Your Ref: OWPC17874
Our Ref: R/51/18/HH 01-03-2018
Please ask for:
Ross Leal

Demolition of existing single garage and erection of detached double garage.

27 Jubilee Avenue Rustington

Project:	
Proposed new garage 27 Jubilee Avenue Rustington	
Drawing: Plans and elevations	
For:	
Drawn:	Date:
Scales: 1:100 1:500	No:

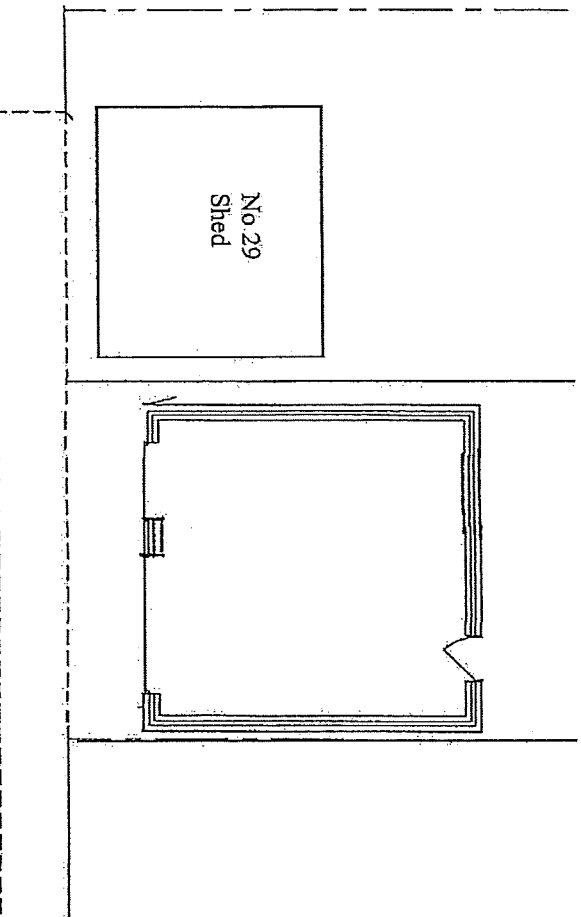
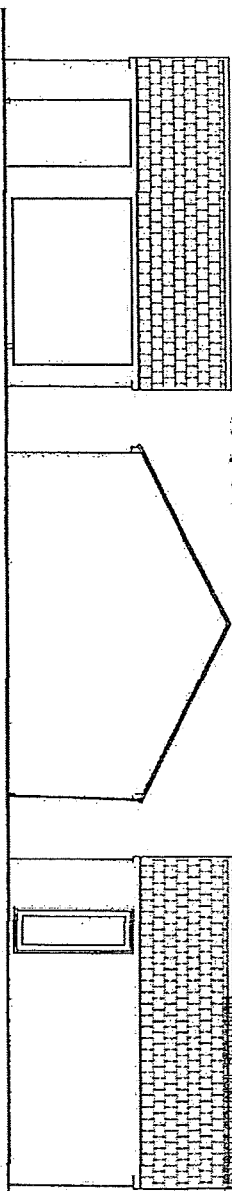
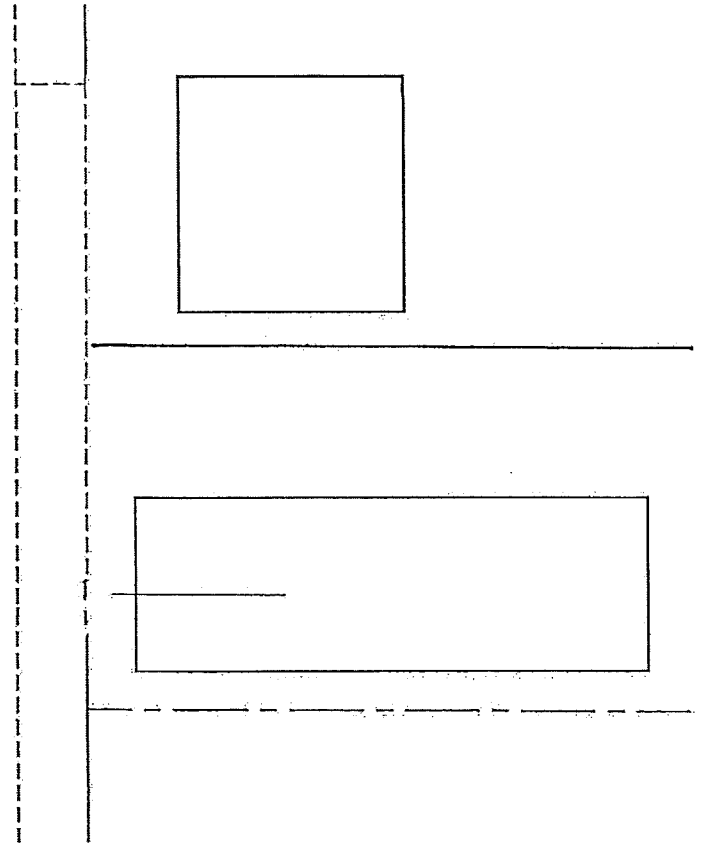
We are concerned because already the concrete base and structure has already been built and at no point was this discussed with us. We only noticed the planning application this week after coming back from holiday. The height of the new garage which will have a apex roof and not a flat one will be detrimental to our property because of the height , as this will be significantly higher than the previous garage . We will loose natural light at the end of our garden and it will be an eyesore every time we look out or sit in our garden .
